PROPOSALS FOR THE DEVELOPMENT OF WEST BURTON C (EN010088):
THE FORMAL RESPONSE OF BOLE VILLAGERS FOR DEADLINE 2,
TOGETHER WITH THE APPLICANT'S RESPONSE FOR DEADLINE 4

Drawing Number 60527350/WBC/ES/FIGURE 4.2a	Rev 0
---	----------

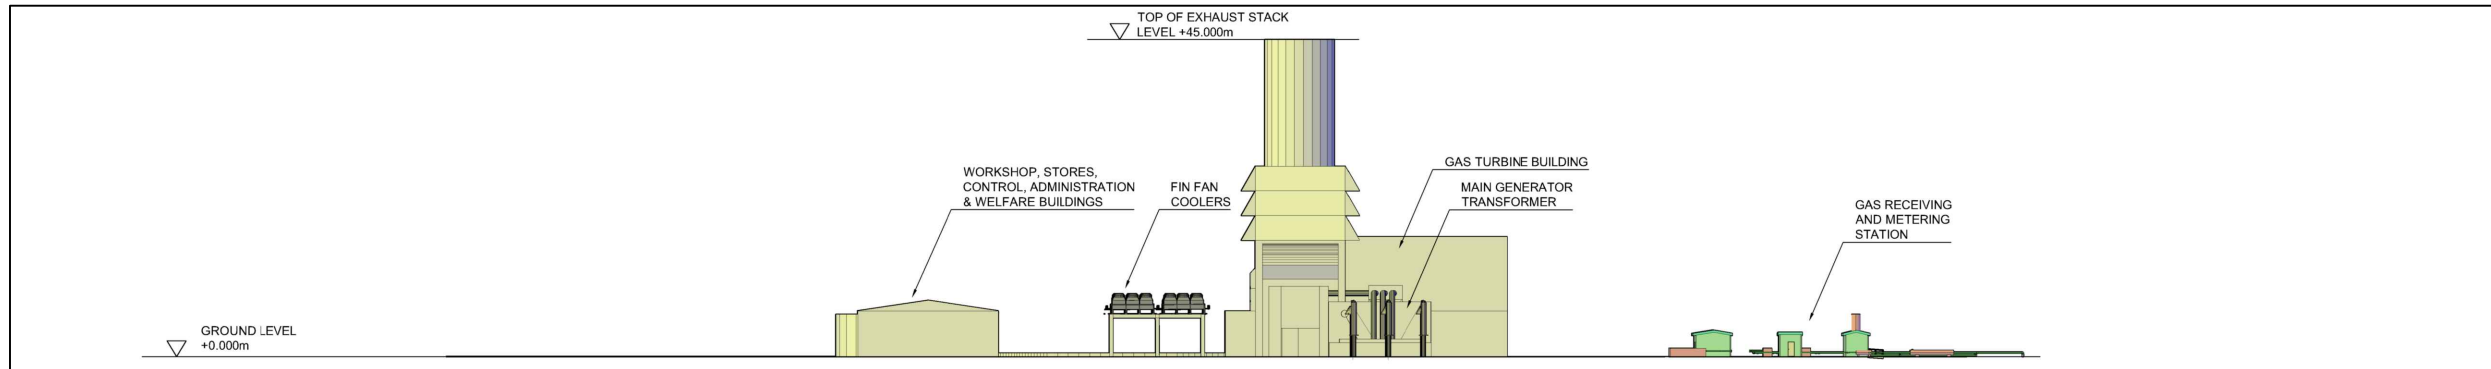
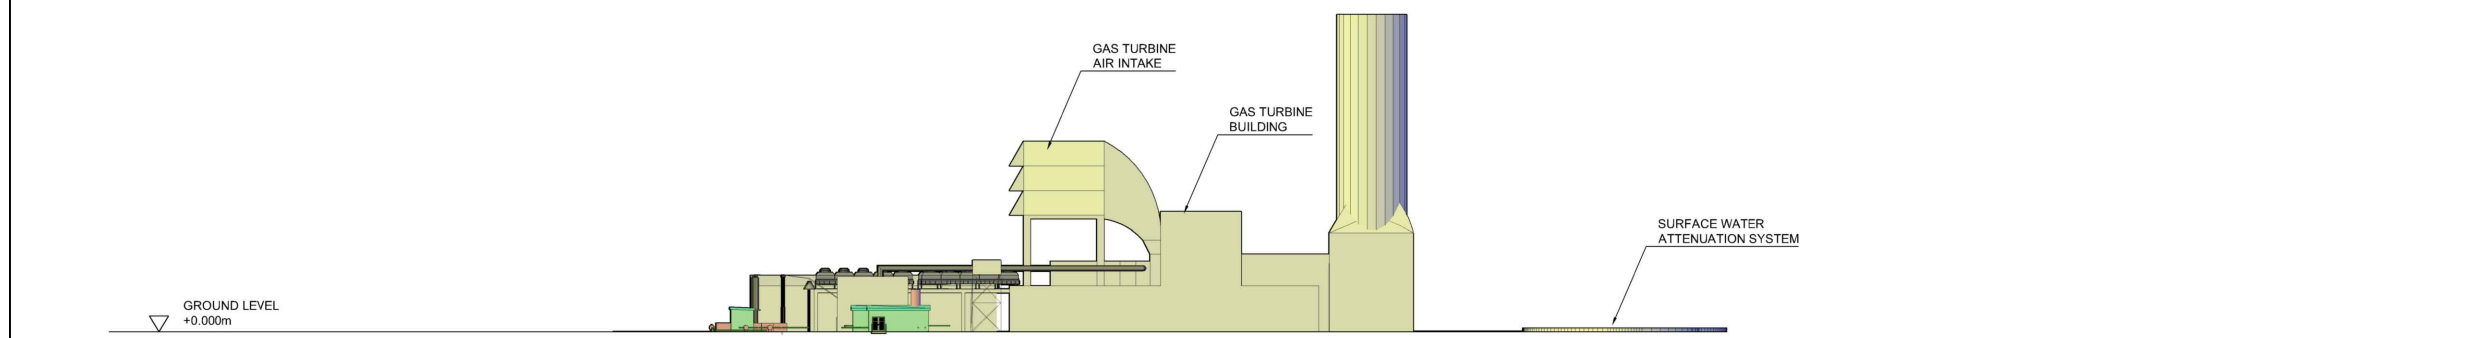
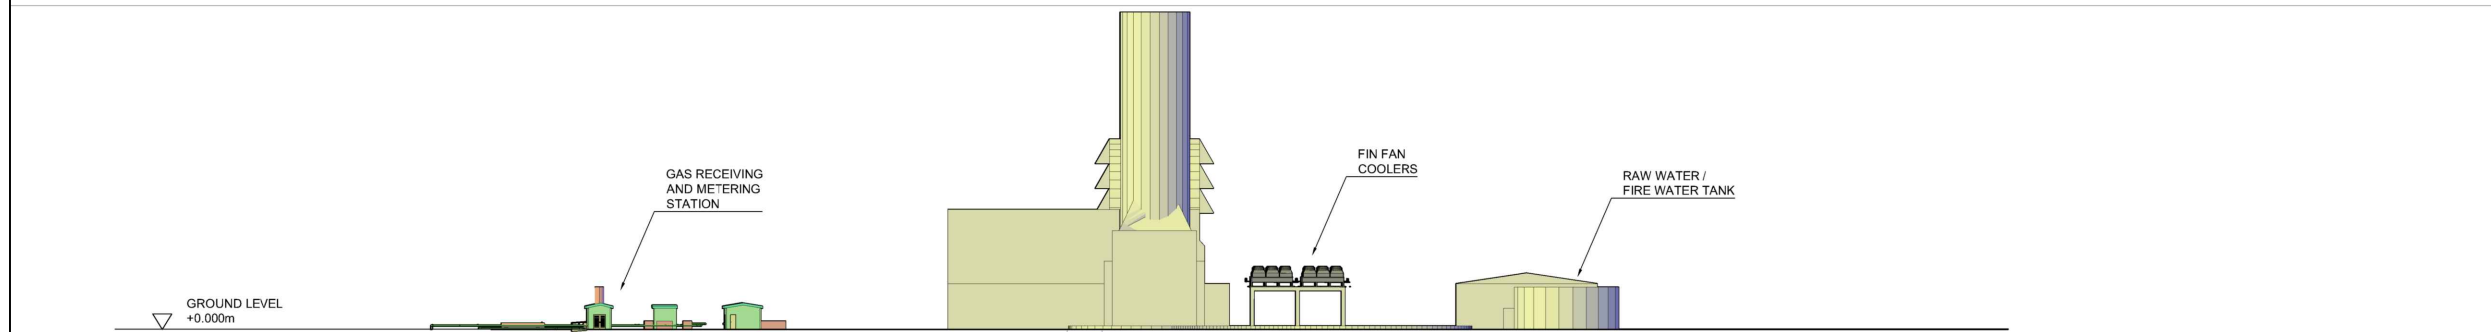
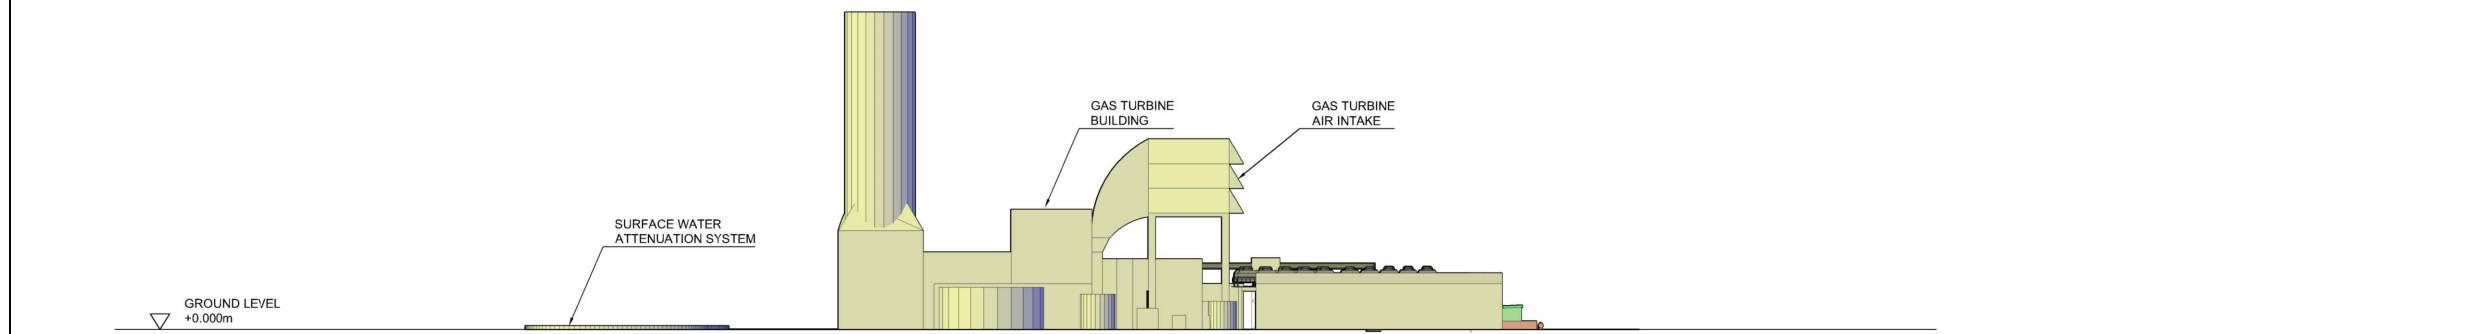
N/A	N/A	Is there any clarity on the proposed height of said stacks?	The maximum stack heights are included in the Environmental Statement. They will be up to 45m high above ground level. For reference this

Original request	EDF Energy's proposal	Bole villagers' response	EDF's Response
			is roughly the height of the turbine buildings on WBB, while the stacks on WBB are circa 75m high.
N/A	N/A	Is there any data on how many peaking / other plants are being built nationally?	The number of peaking and other plant built nationally will be determined by factors including: regulations and incentives, fuel prices, technology development, economic growth, commercial conditions and decisions taken by individual project developers. The Applicant is therefore not able to provide a specific response to this question. However Government projections indicate that additional peaking plant capacity will be required in the UK as intermittent renewable electricity generation increases.
N/A	N/A	Is EDF Energy committed to keeping local residents informed about progress? We would like to be kept informed if possible.	Yes, EDF will endeavour to keep the local community informed about the progress of the construction of the development through contacts with the local MP and councillors.
